CITY OF ALBUQUERQUE

September 10, 2018

RE: **6212 Tesuque Dr NW**
Grading and Drainage Plan
Engineer's Stamp Date: 9/5/18
Drainage File: E10D049

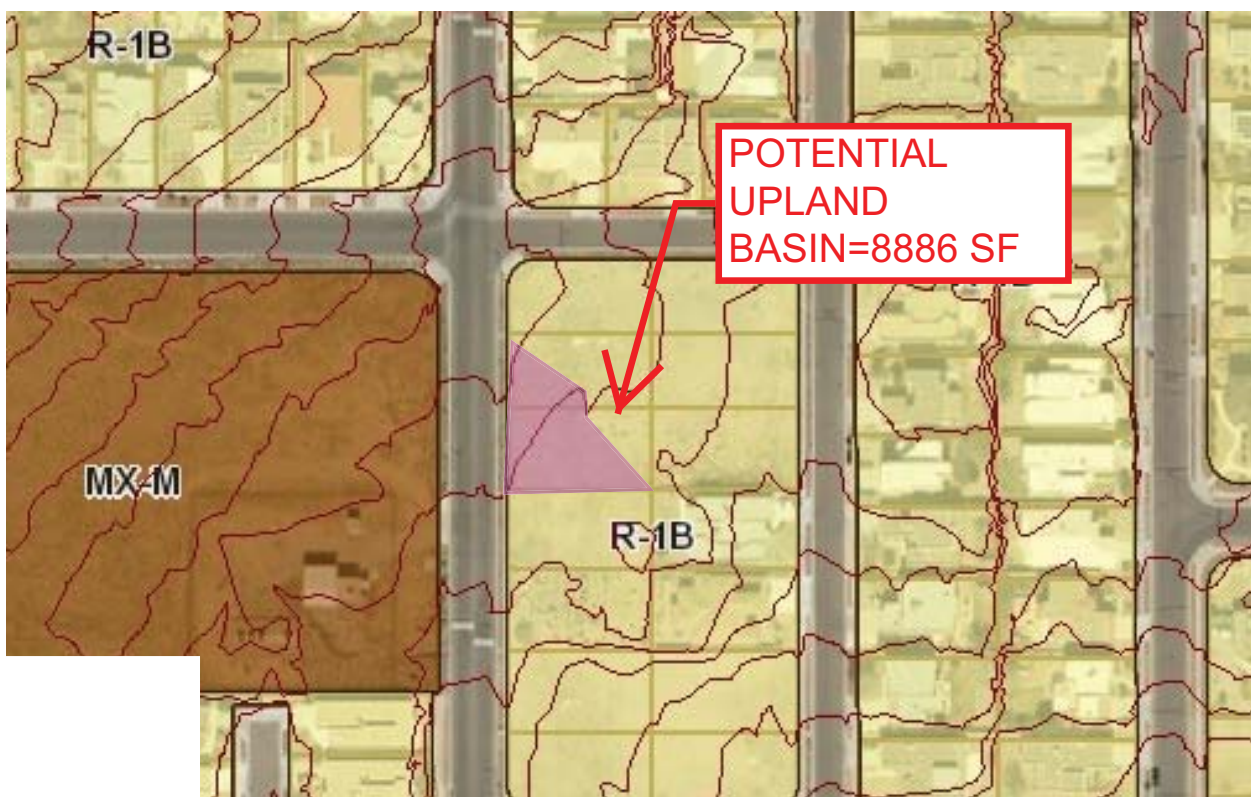
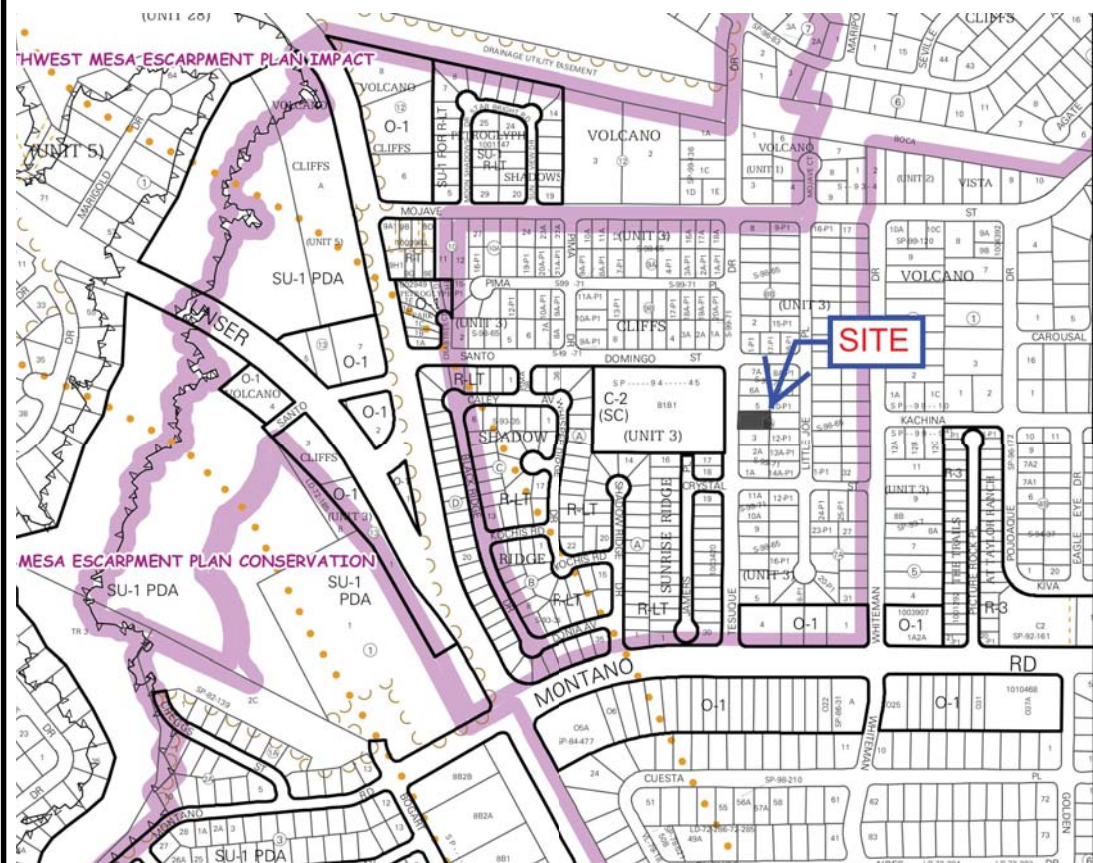
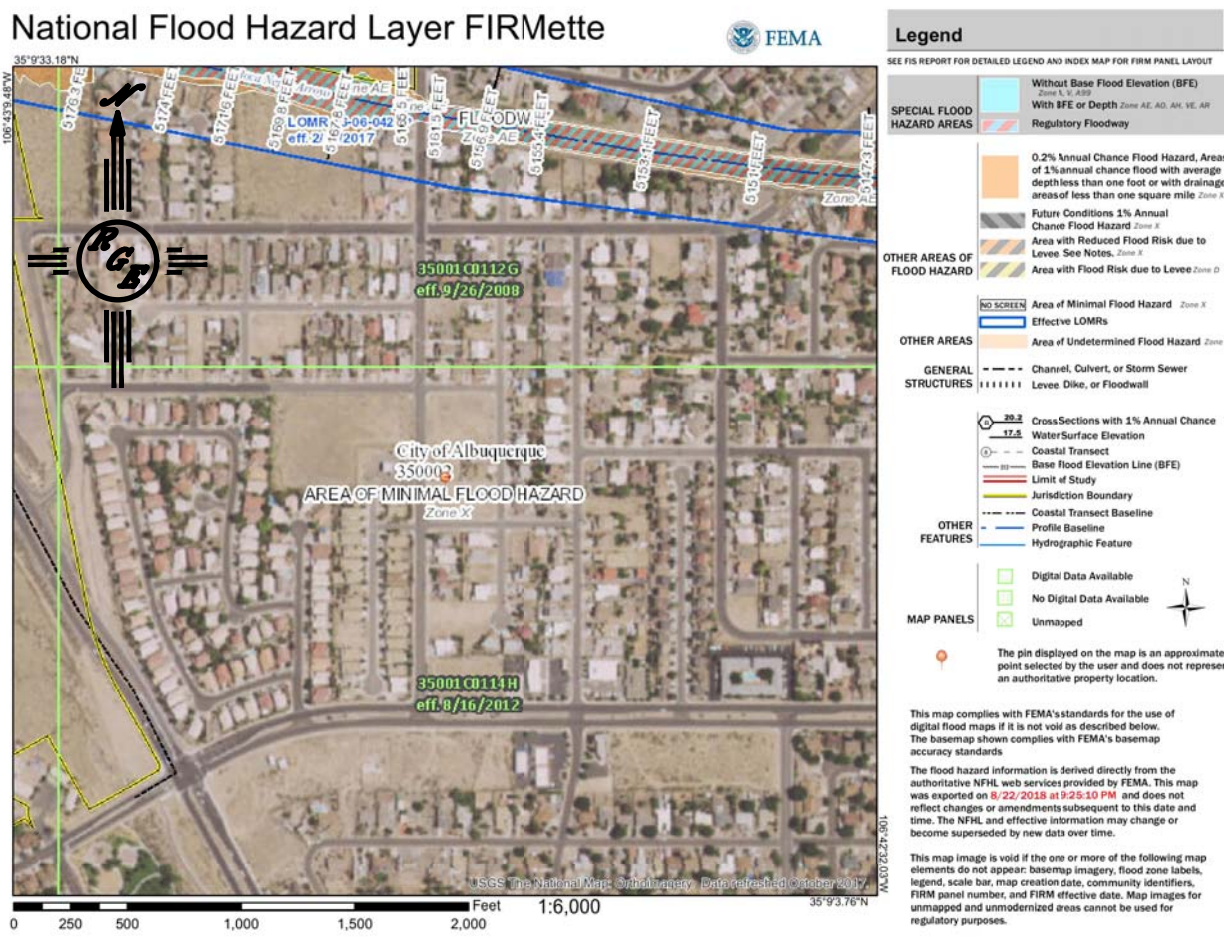
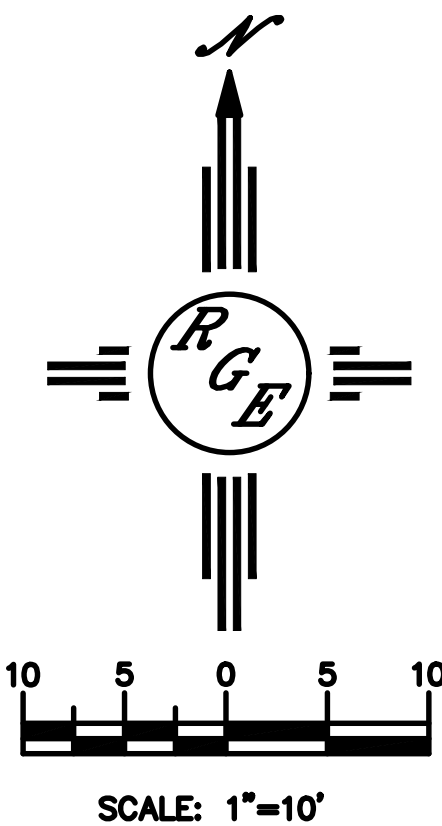
1. The narrative refers to SAD 221, but the site is not located in this SAD. The narrative and drainage assumptions need to be updated accordingly. The backyard ponding needs to be sized for the 100-yr volume for the area draining to it, but subbasins are not provided. Is it feasible to drain the entire roof area to the street? It seems as though some of it will need to be ponded in the backyard. **We have sized pond and shown basin that will drain to street, this site was in SAD 224**

2. Provide wall sections through all perimeter walls showing footers, property lines, existing and proposed grades, horizontal and vertical dimensions. Demonstrate that grading and wall construction near the property line will not endanger adjacent property or constrain its use (DPM Ch.22, section 5 part B). Any private encroachment into neighboring private property will require written and signed permission from both property owners.
Added detail and note
